Ref : AB/118/20/PL
Proposed development at 70a Tarrant street. BN18 9DN

I am writing to object to the proposed development. My objections are as follows:

Ground Floor - Proposed

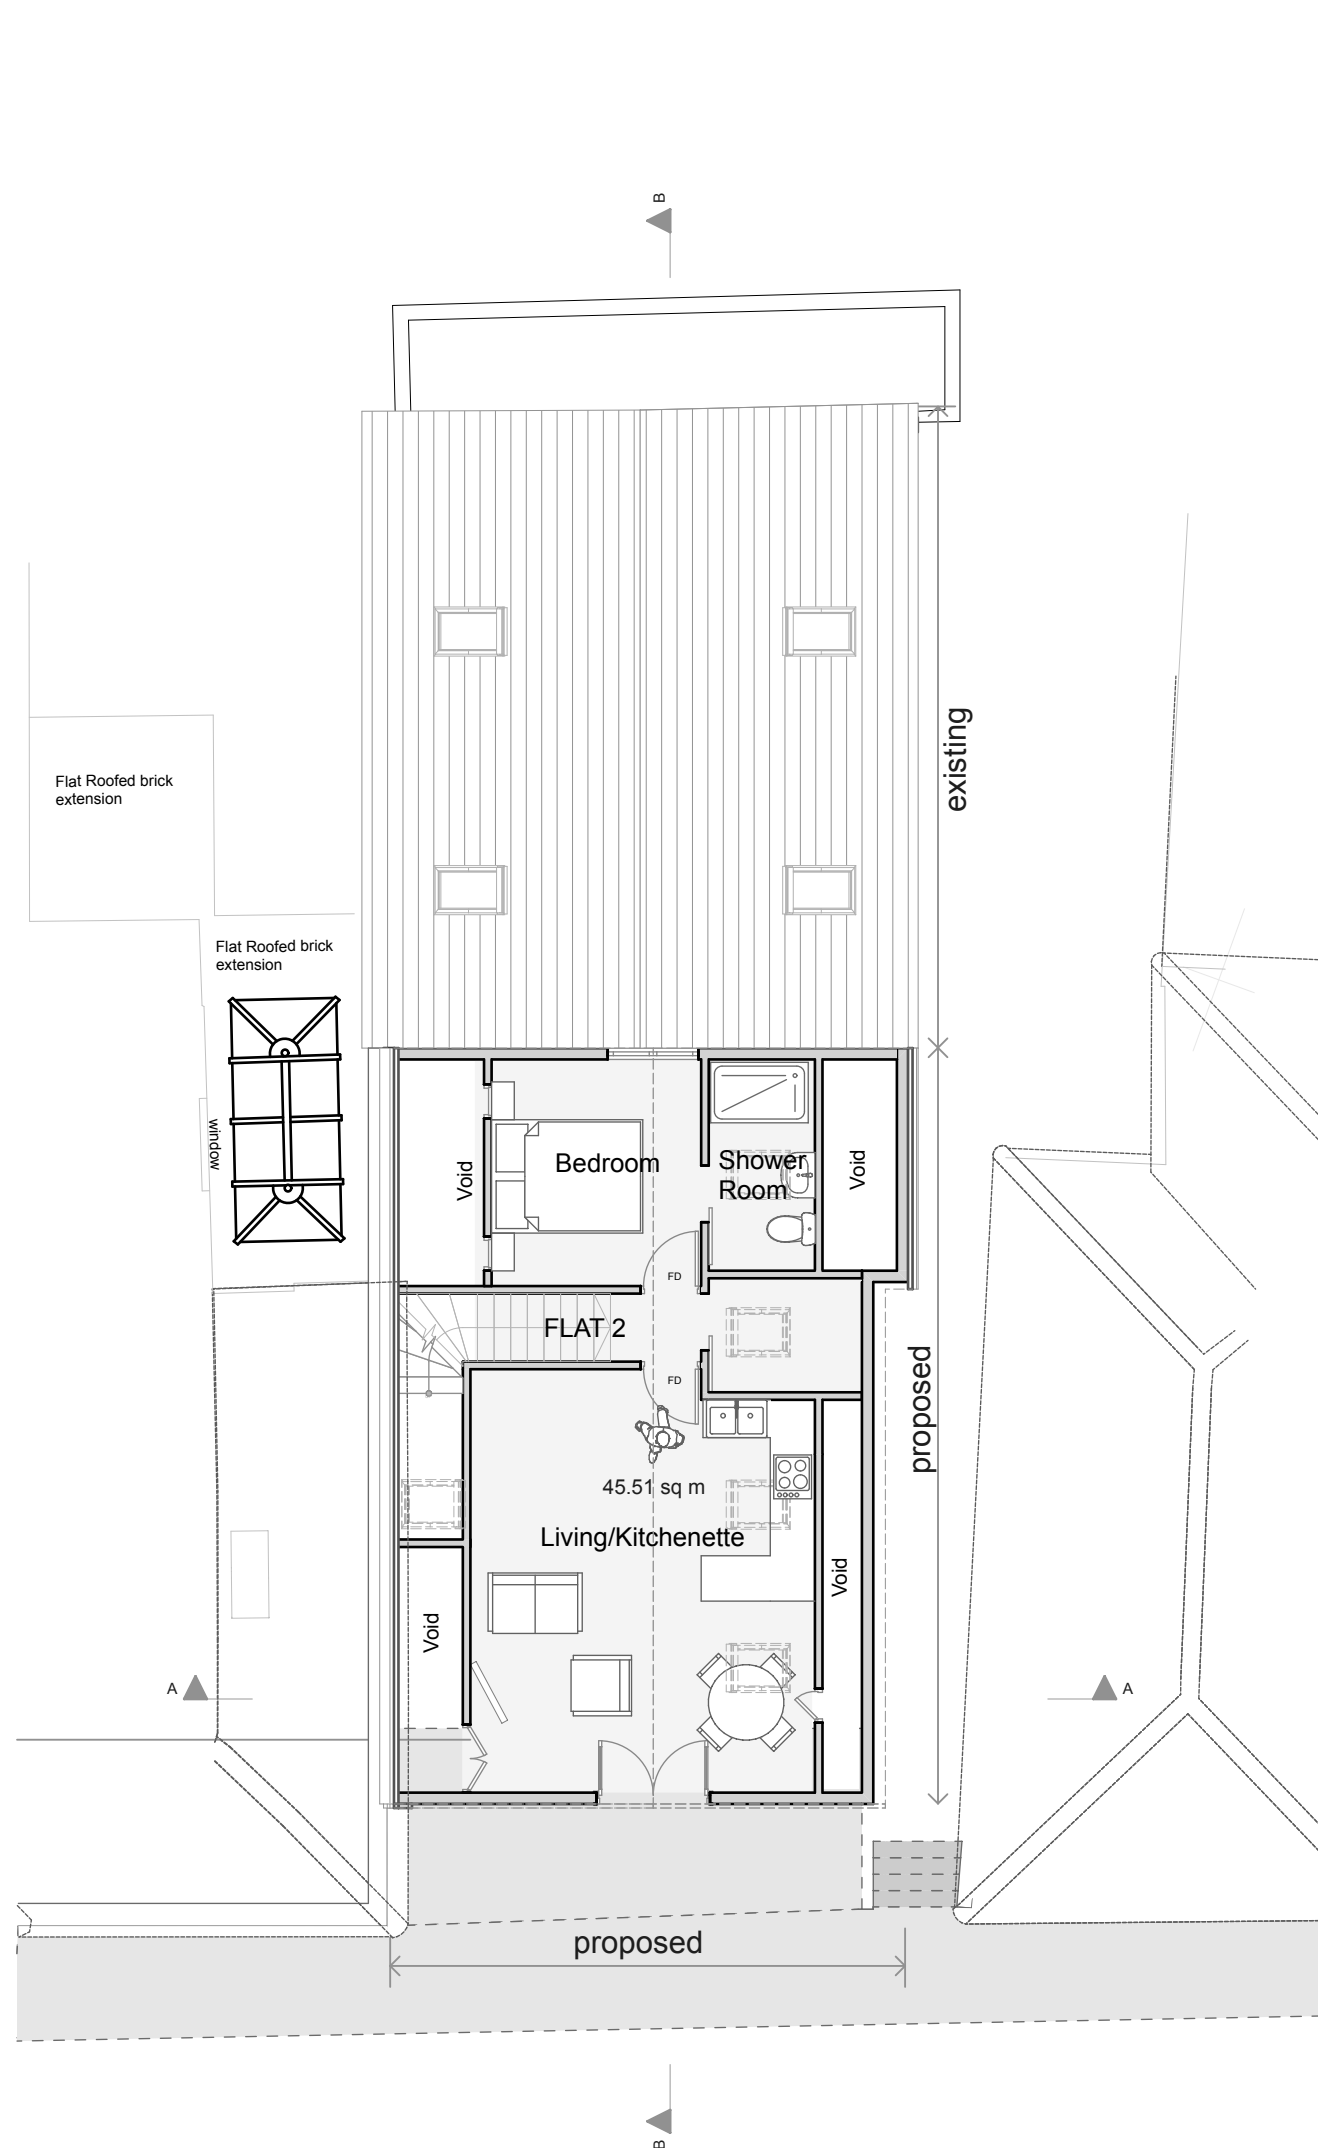
Incomplete and incomprehensible plans. There is no scale on the plans and no benchmark making it impossible to ascertain the height of the roof and the distances and measurements of the building. In the Wightman statement contained in the Application the photograph of the flank wall of 64 Tarrant st. does not show the four existing windows giving the impression that there will be no ill effect from the construction when in fact a huge percentage of light will be lost to the windows of 64 by the erection of a wall four feet from the flank wall, up to the roof line. There is also no indication of windows overlooking 70 Tarrant st when the developer himself has told me that there will be overlooking windows. This gives a distorted impression of the negative impact on both 70 and 64 that the new development will have. Juliet balconies are not in keeping with current architecture and do not improve the existing street scene. The large windows when open will create additional noise from the inside of these flats and cause loss of privacy to the houses on the south side of Tarrant street.

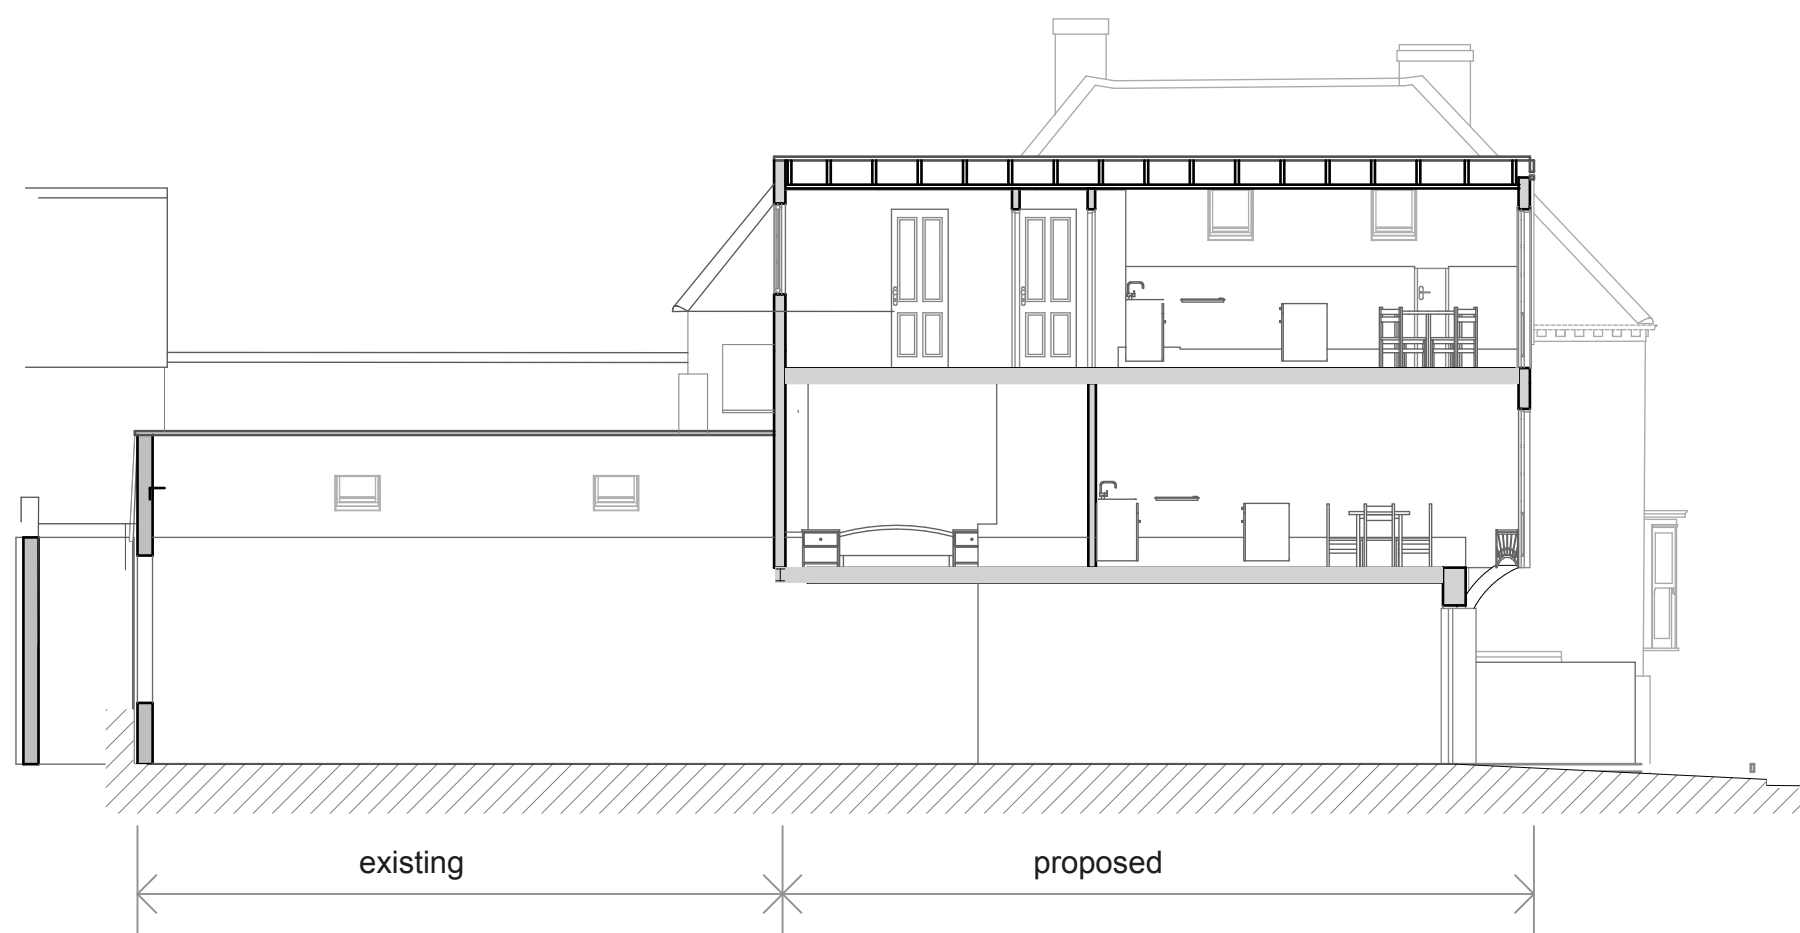
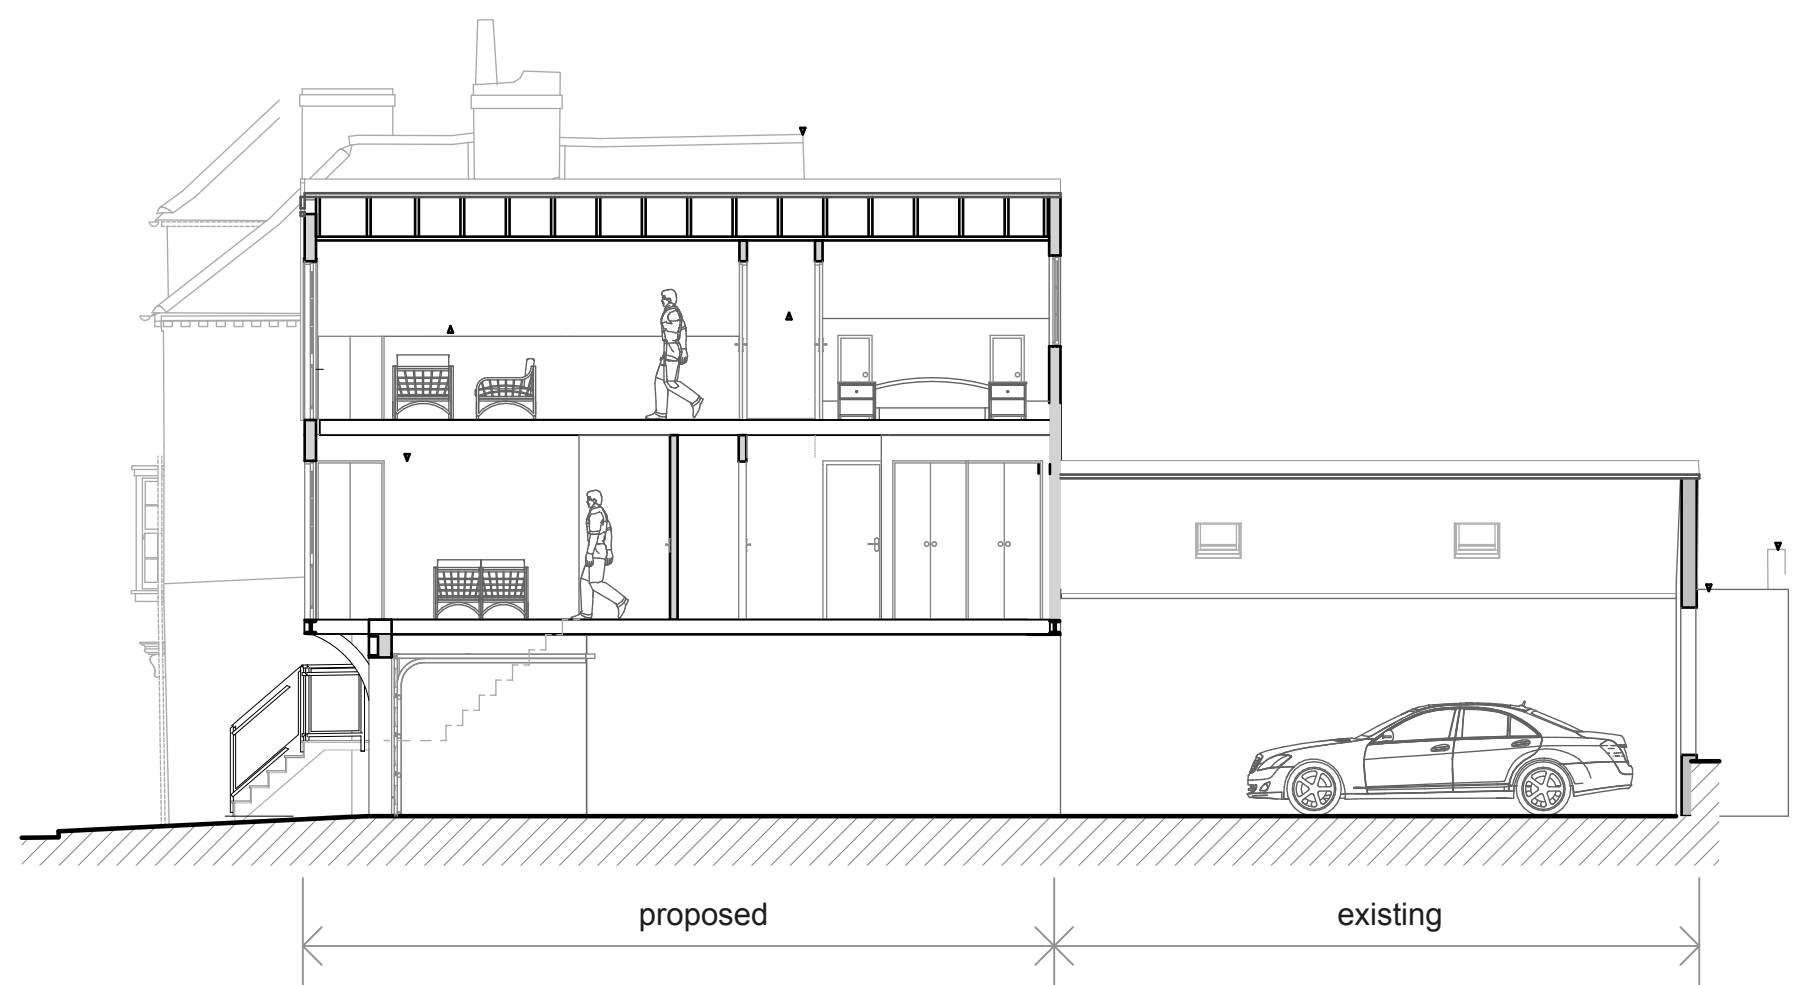
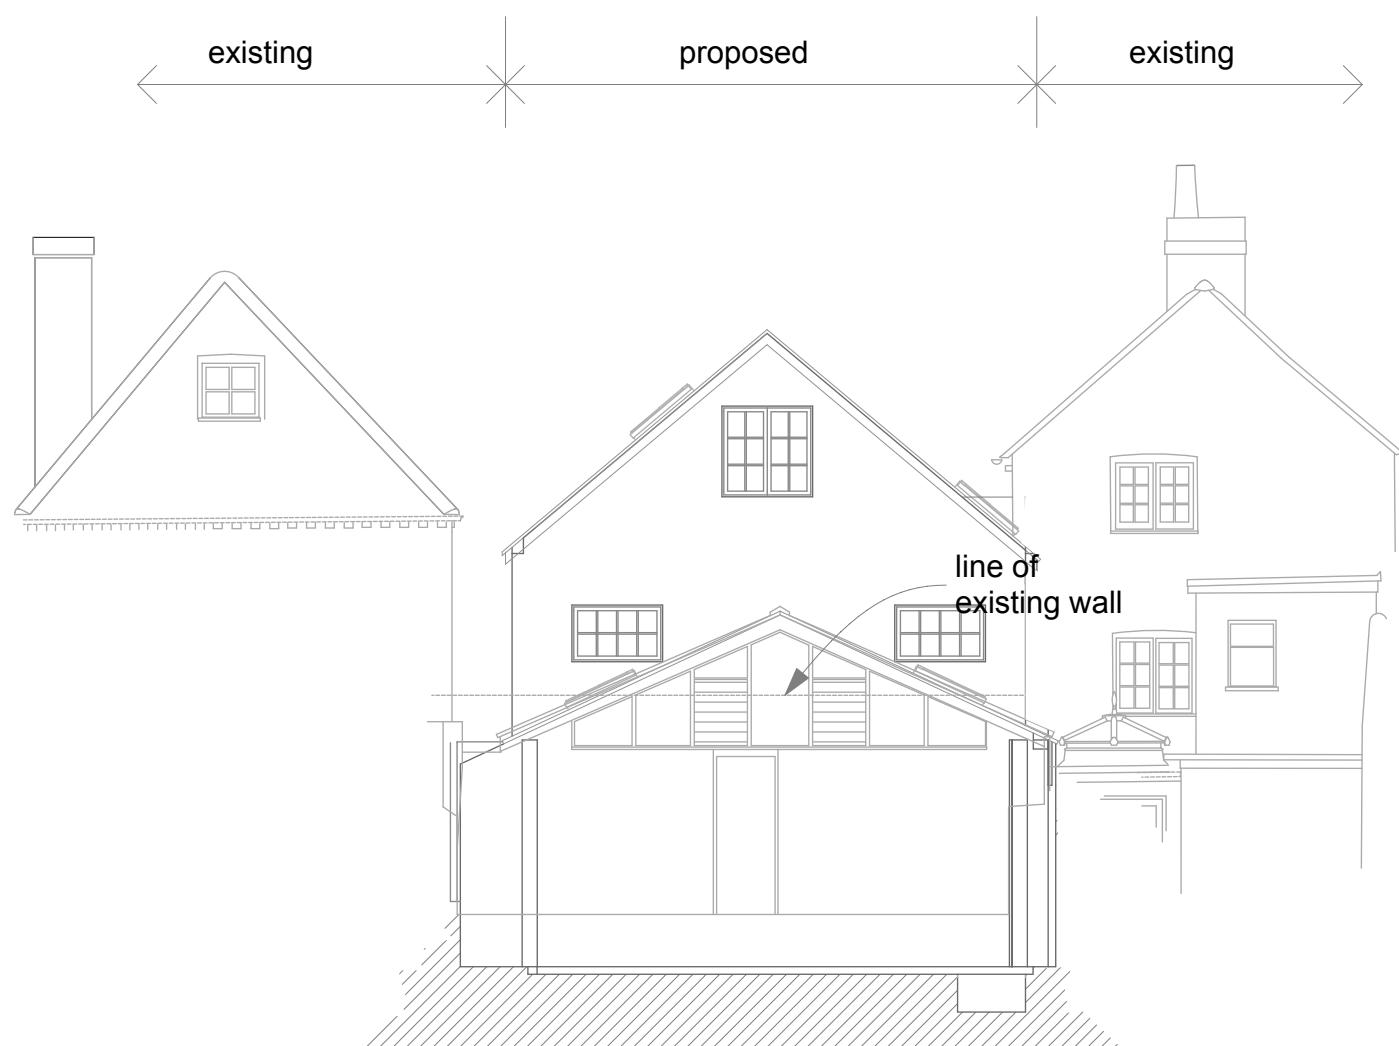
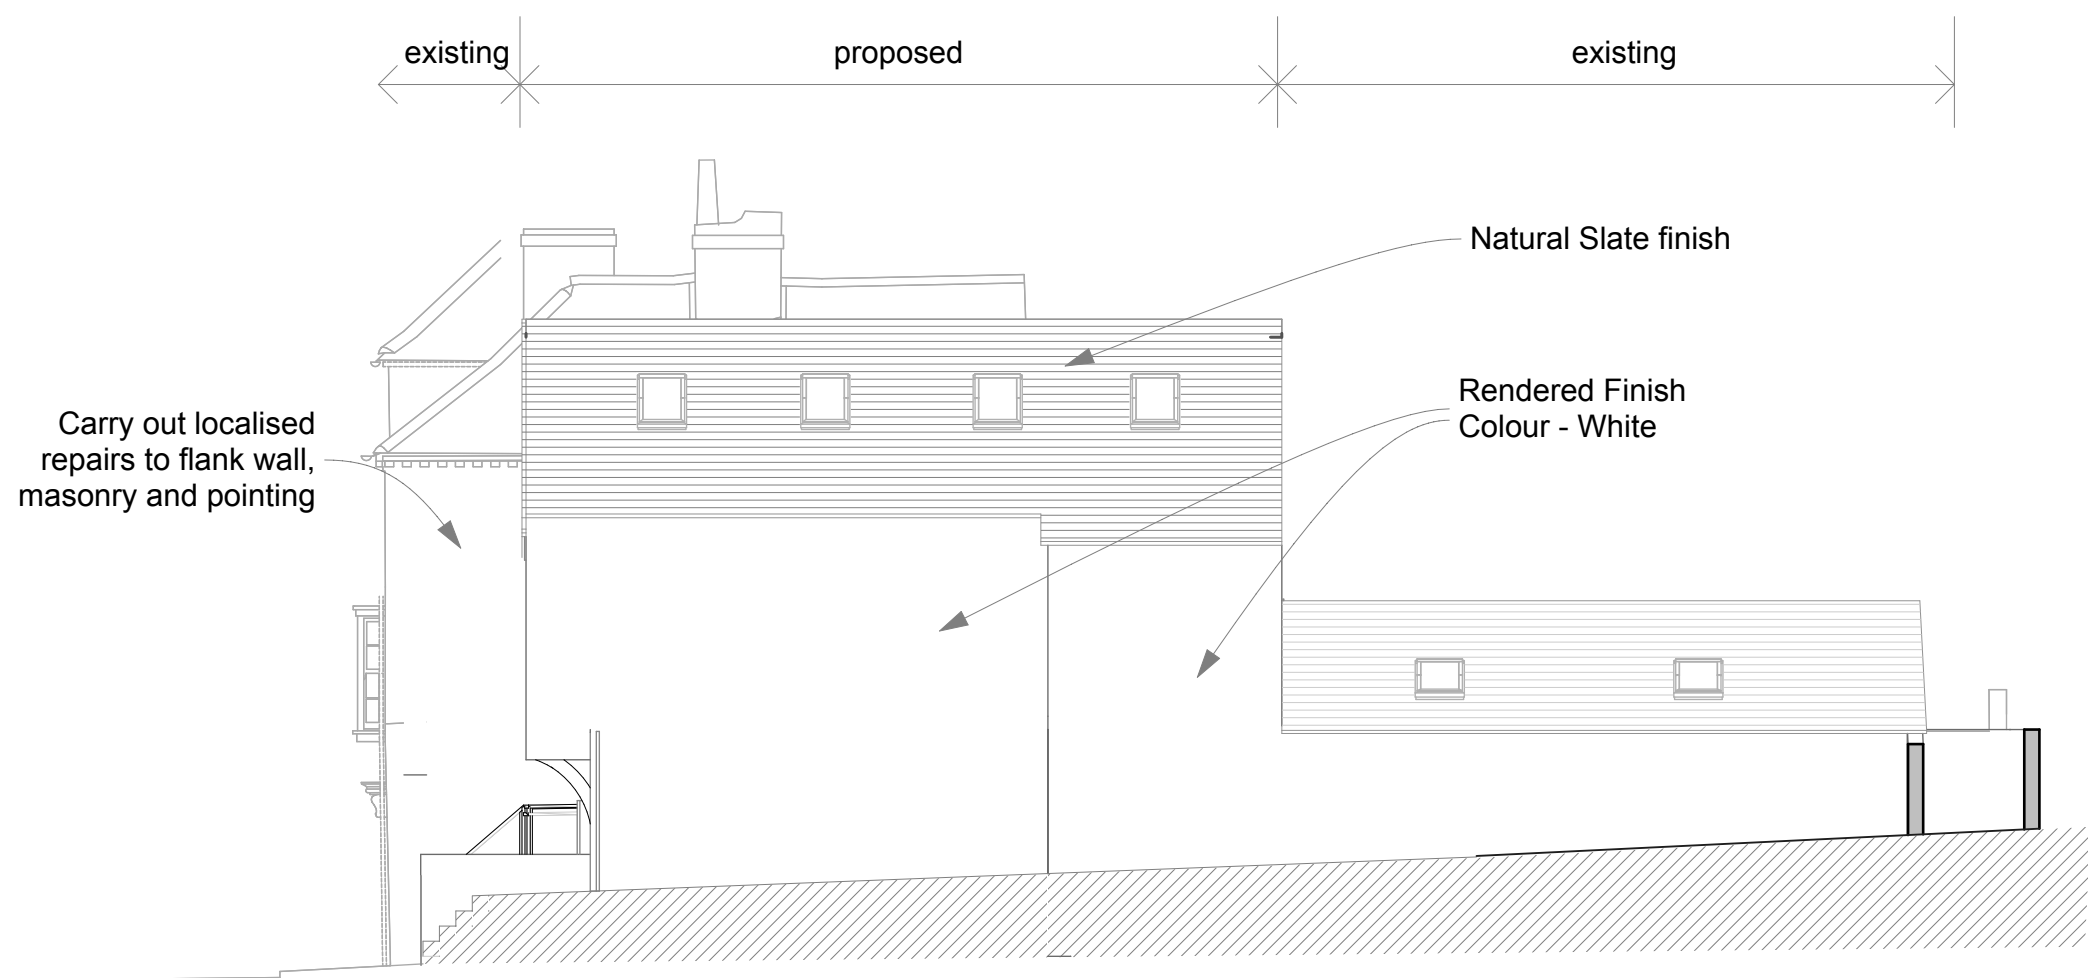
The window (which I cannot see on the plan but which the developers informed me would exist) would look straight into my room and would completely destroy all privacy, window or no window. I could not be more infringed upon and the quality of my life would be badly compromised by these negative impacts if the Plan were given approval.

The development comes back too far extending past the end of my house a further 12 feet. This is much further than the proposals lodged in 2007 (where the building proposed to come back as far as the end of my house, and thereafter it was to continue on as one storey) and is a case of massing causing extreme overshadowing and overlooking which in turn causes loss of privacy. The proposed construction is out of line with the back of both 70 and 64 and is so intrusive and invasive blocking light and aspect causing an extreme feeling of being hemmed in and overlooked.
